# CITY OF ALBUQUERQUE

March 22, 2021

**RE: Lot 17 Block 1 Volcano Cliffs Unit 22 SAD 228  
8015 Agua Fria Ct. NW  
Grading and Drainage Plan  
Engineers Stamp Date: 10/19/2020 (D10D003N17)  
CO Certification Date: 3/11/2021**

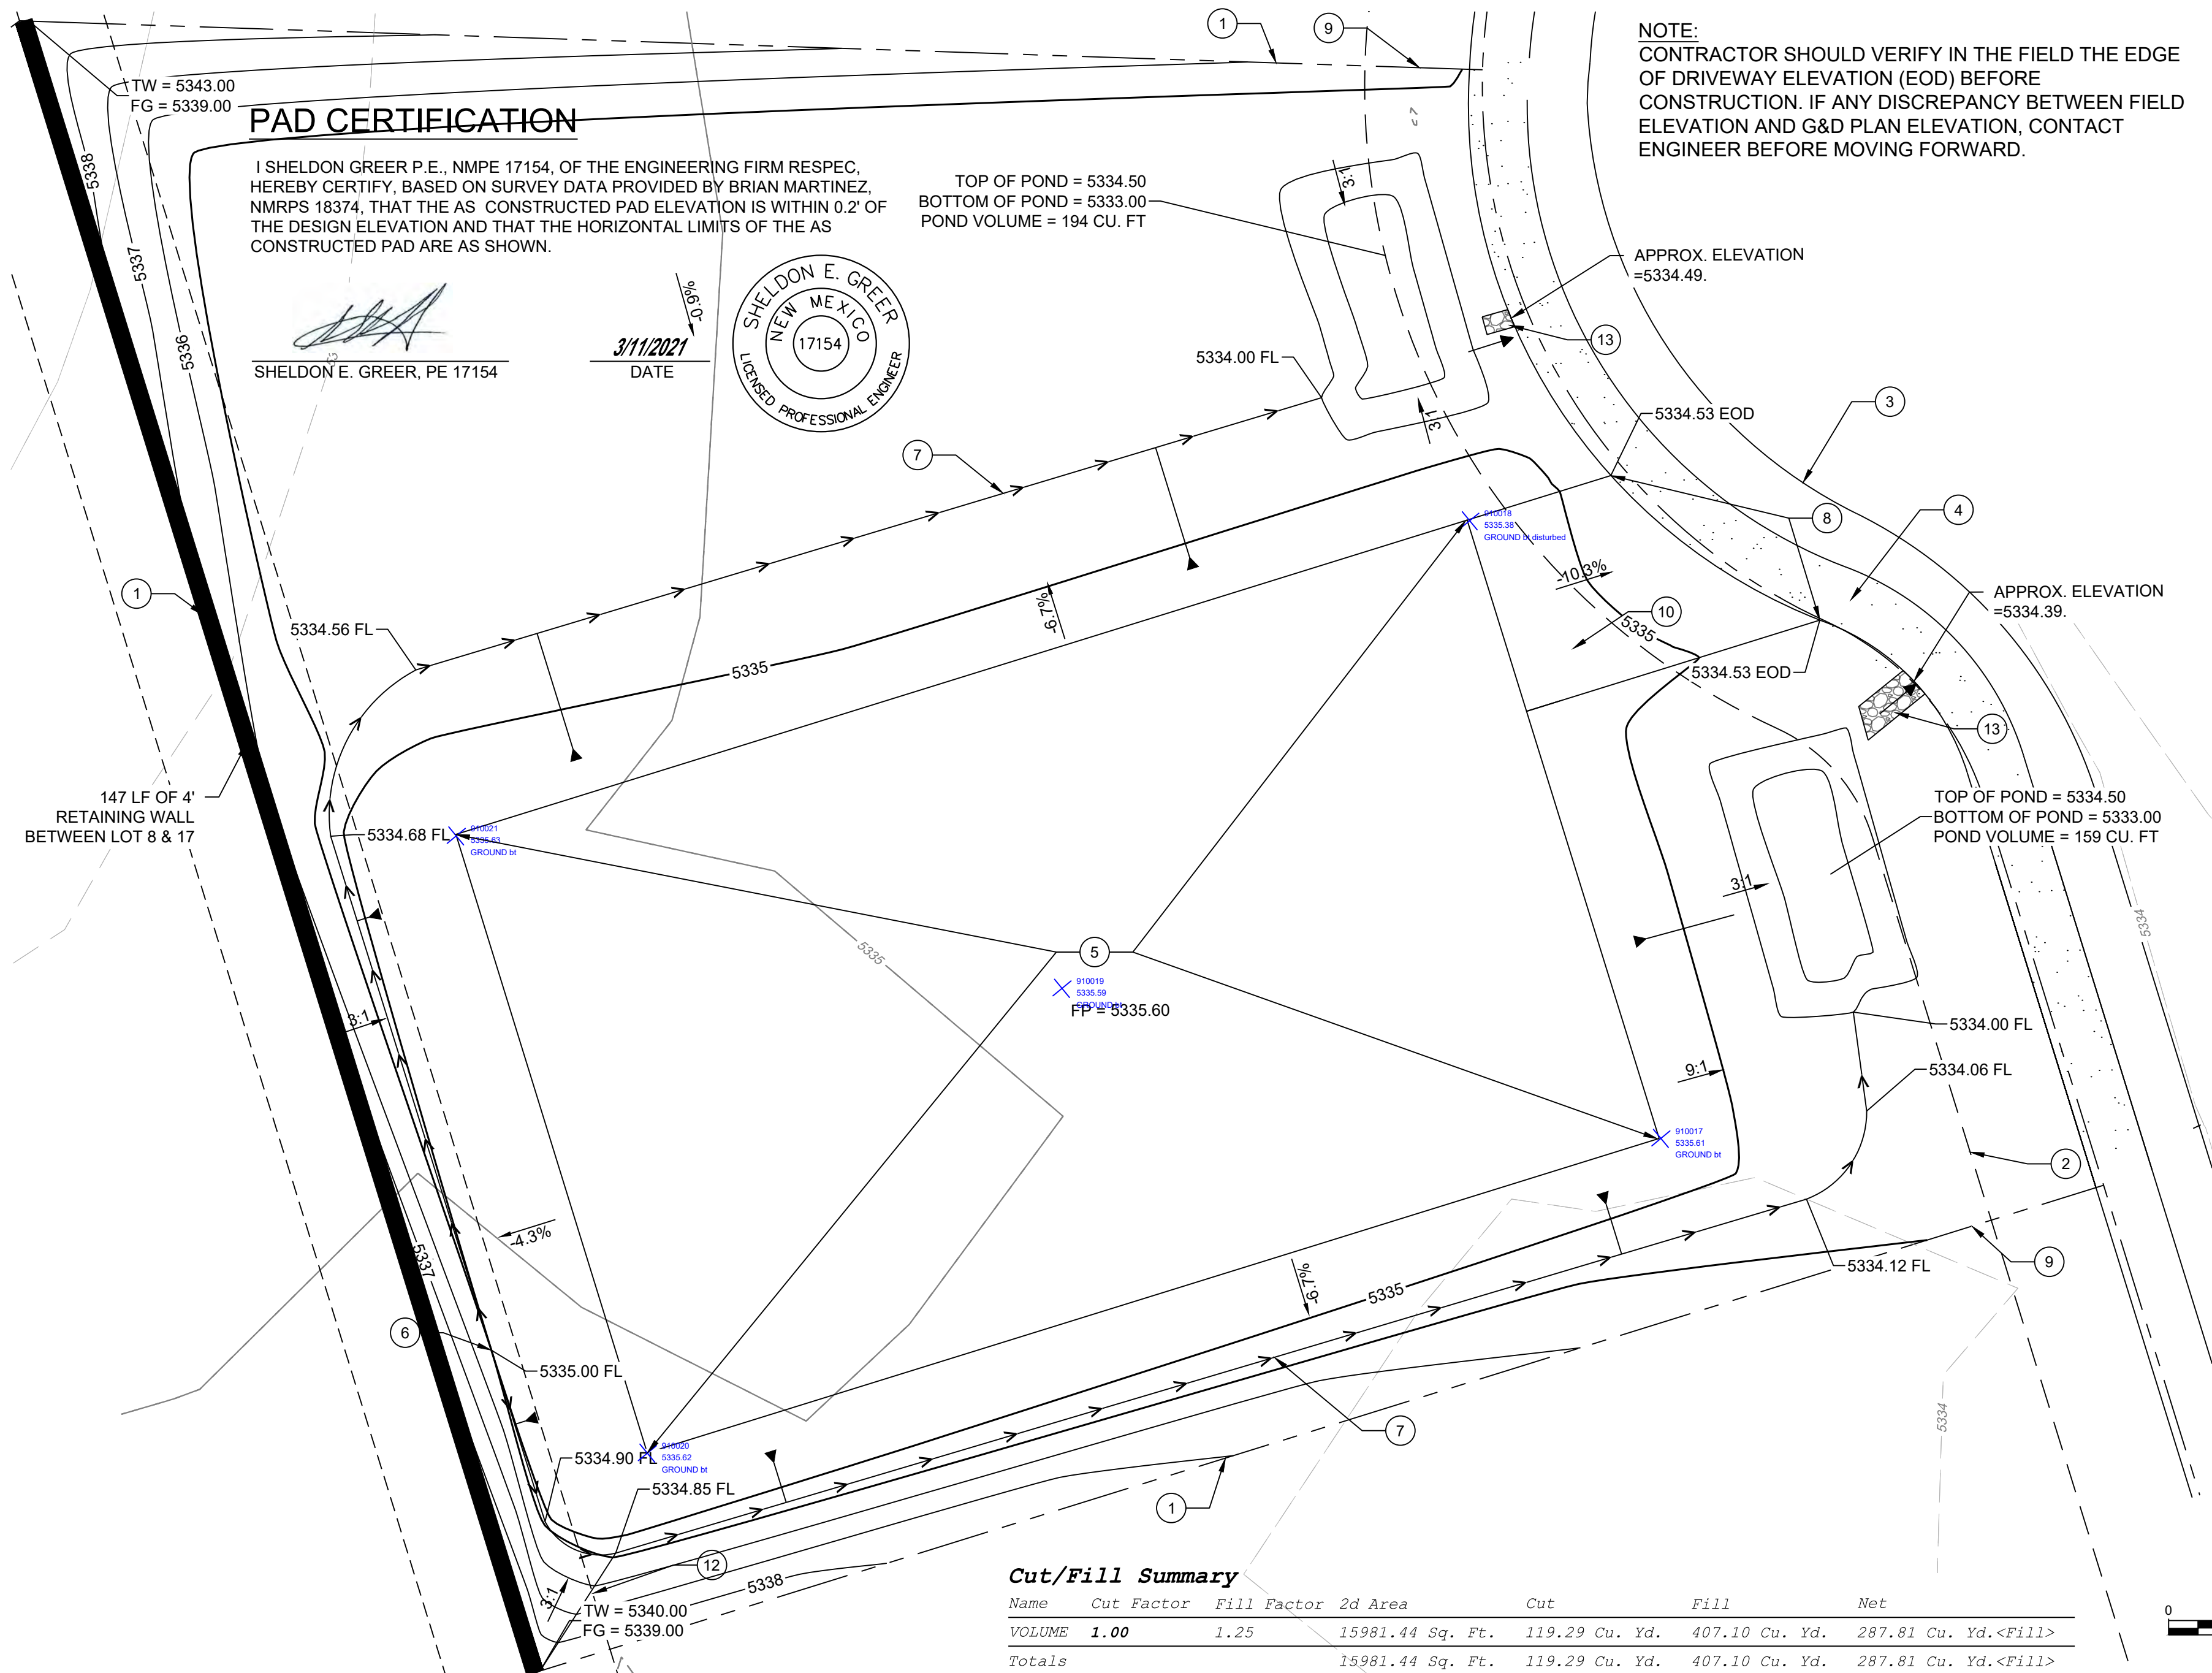
- Lot did not have an address, provide address
- Have all dirt ramps removed from the streets. Crusher fines or lumber are to be used for driving over a curb.
